Dear Ms. McGuire:

I'm writing to provide additional input on Mercer Island Permit Application 2207-019's recent [submission response memo](#) (SUB2) and corresponding revised [plans](#). On October 25, 2022, I and my attorney, Zach Davison, submitted comments during the public comment period on the initial plan set. This letter supplements those comments in response to the revised plans submitted by the applicant on March 1, 2023.

BUILDING ELEVATIONS

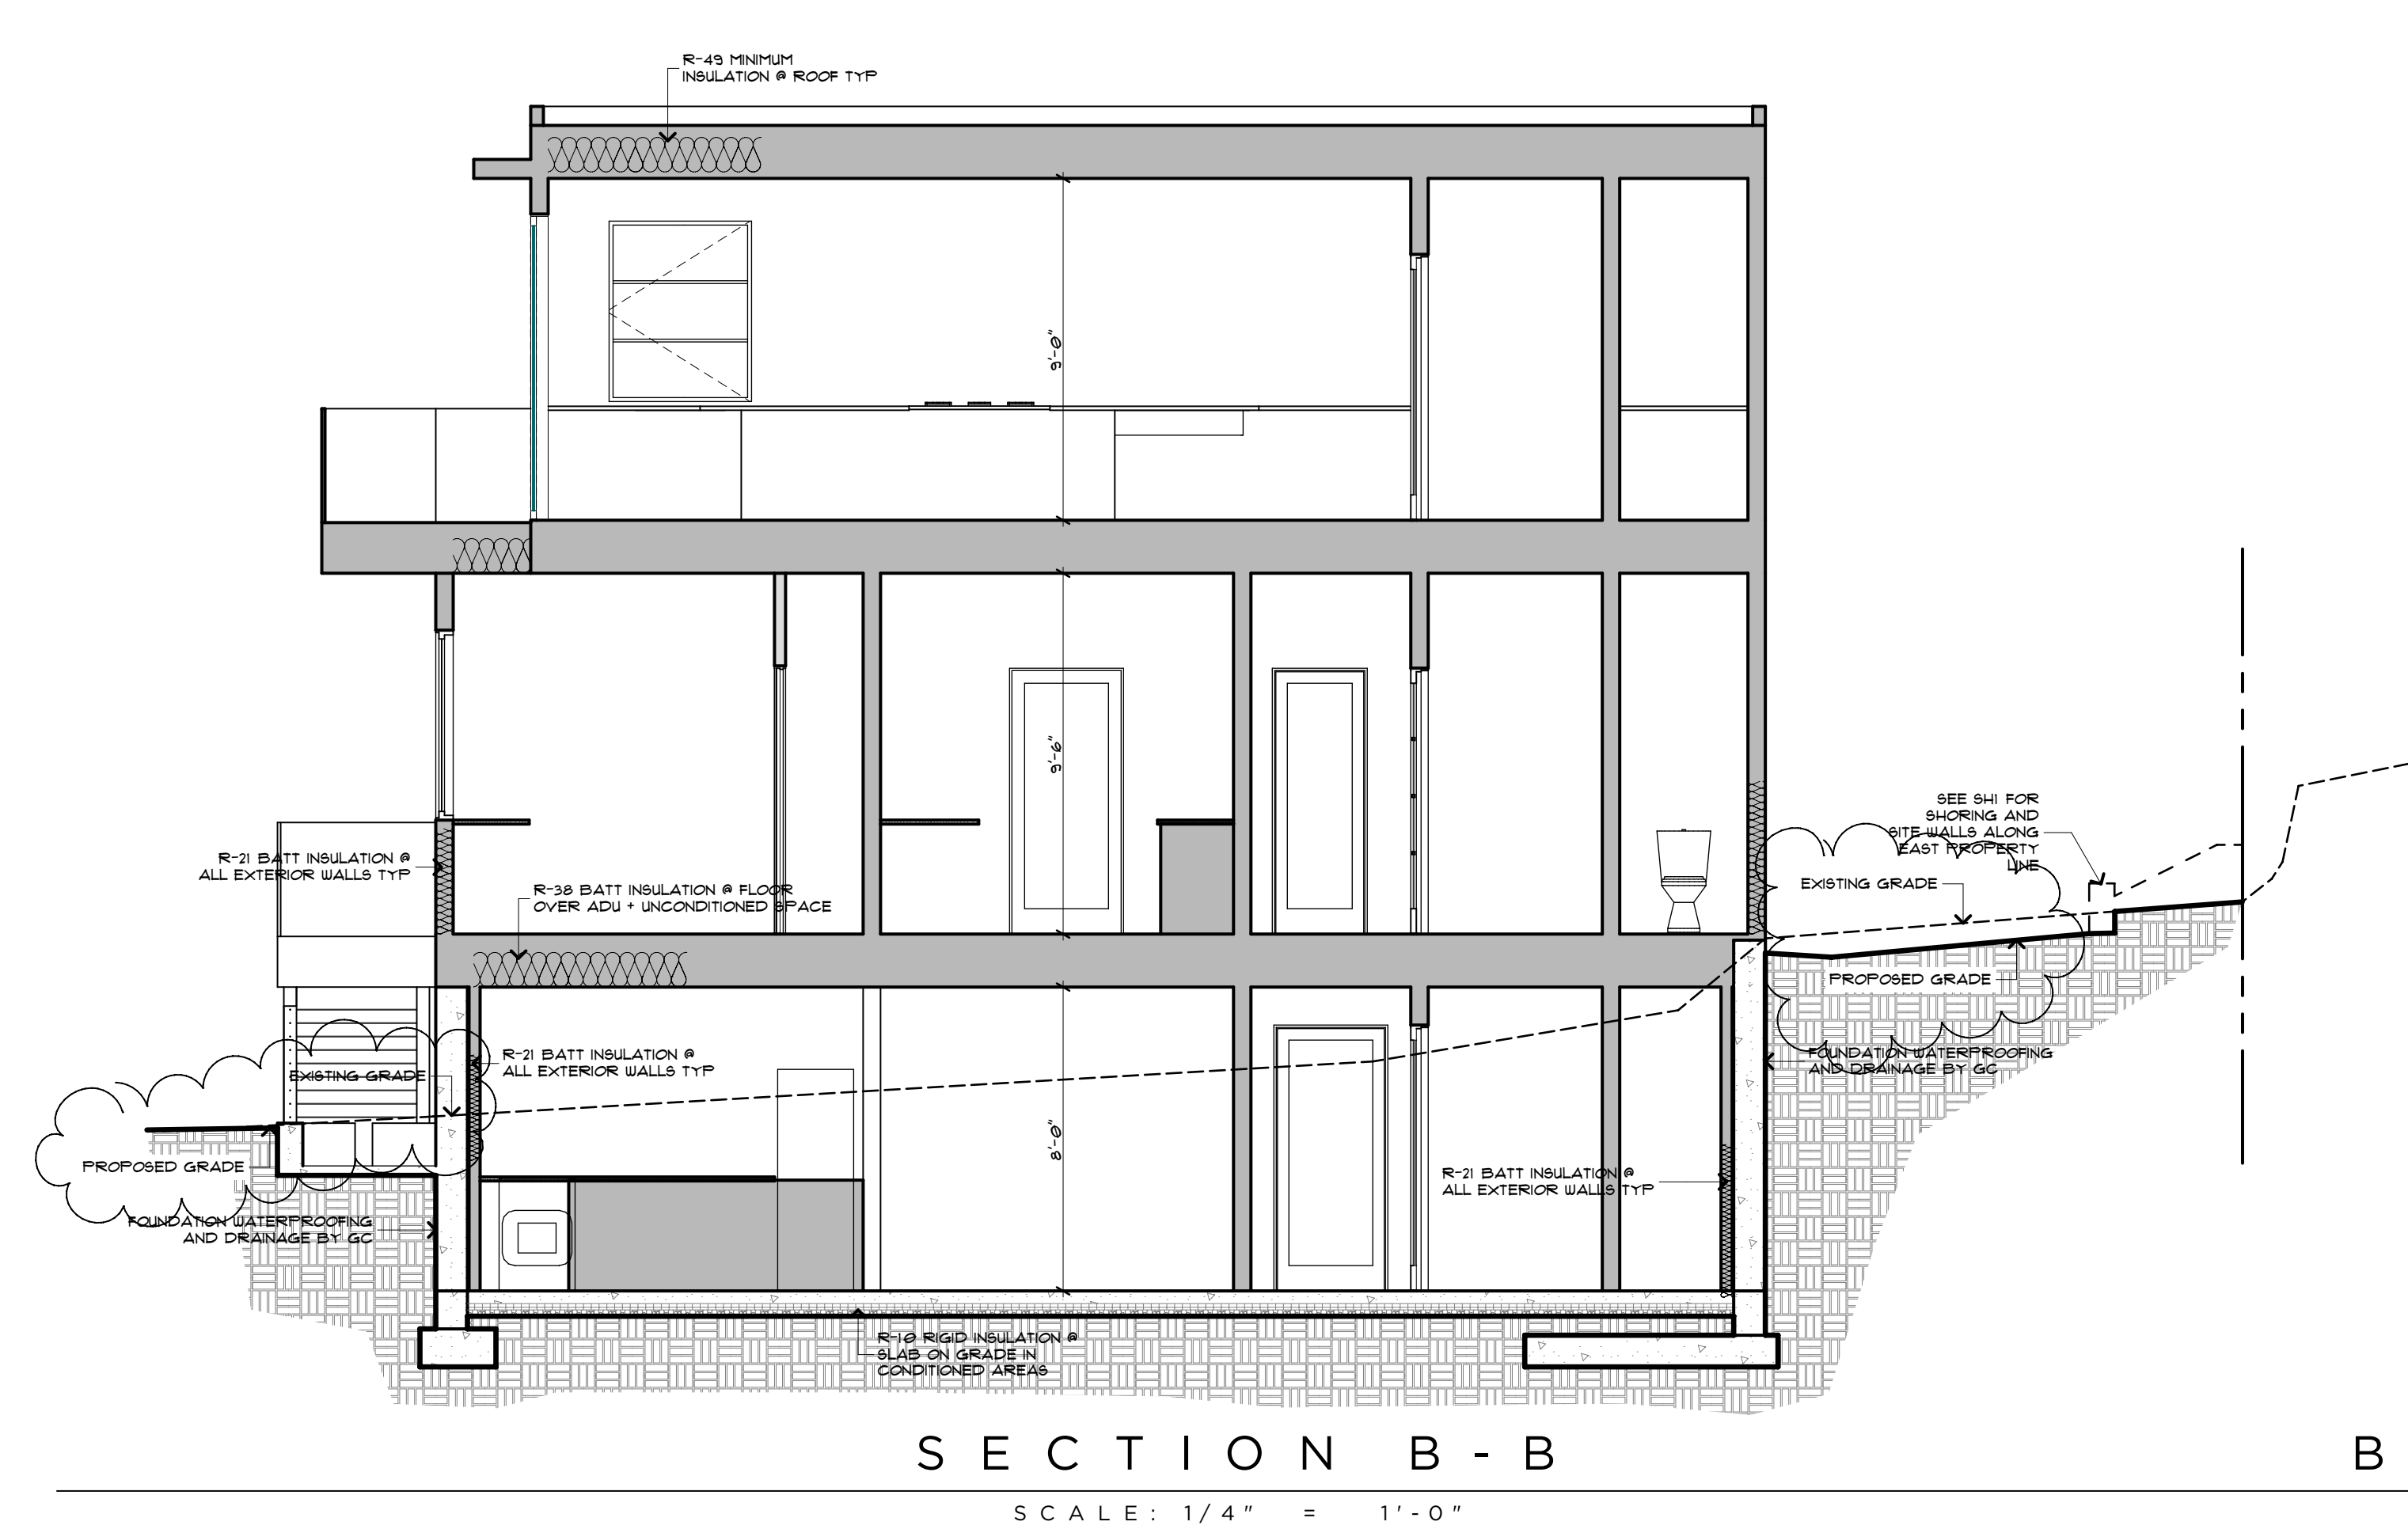
- West elevation:
 - Covered wall surface at Finished Grade shown in gray, uncovered in red. this shows coverage of ~33% based only on Finished Grade. Precise computation requires clear elevations for the ground floor ceiling and Level 1 FF, which are unavailable.
 - Existing Grade is incorrect, as shown earlier.
 - 2021 Grade appears to be correct.
 - Coverage is incorrectly computed.

North Elevation:

- Finished Grade appears correct.
- Existing Grade is incorrect, as shown earlier.
- 2021 Grade does not match SUB2. The blue area below shows the actual exposed wall in 2021, because part of this wall sits on top of an existing basement.
- Coverage is incorrectly computed.

East Elevation:

- Finished Grade appears correct.
- Existing Grade is incorrect, as shown earlier.
- 2021 Grade does not match SUB2. The blue area below shows the actual exposed wall in 2021, because part of this wall sits on top of an existing basement.

South Elevation:

- Finished Grade appears to be correctly computed.
- Existing Grade is incorrect, as shown earlier.
- 2021 Grade appears to be correct.
- Coverage is correctly computed as 0%.

4. Maximum Building Height on Downhill Façade is shown on the South Elevation of the updated drawings and is measured at 29'-6" to the top of the wall supporting the roof framing per MICC

SUB2 incorrectly excludes the deck railing and the area at the top of the wall from the Facade Height.

By not correctly using the Existing Grade (which is lower than the Finished Grade), the height of Facade is further incorrectly computed.

SUB2 also violates MICC 19.2.020.C.1.c.iii - "Single-family dwellings with a height of more than 25 feet measured from the existing or finished grade, whichever is lower, to the top of the exterior wall facade adjoining the side yard shall provide a minimum side yard depth of ten feet."

The ">25" facade shown below is because SUB2 incorrectly computes the "lower of Existing Grade or Finished Grade" on the East side of the structure.

Note that the Southern elevation facade is a facade onto Side Yard 1 (Side Yard 1 has the facades from both the Eastern and Southern Elevations).
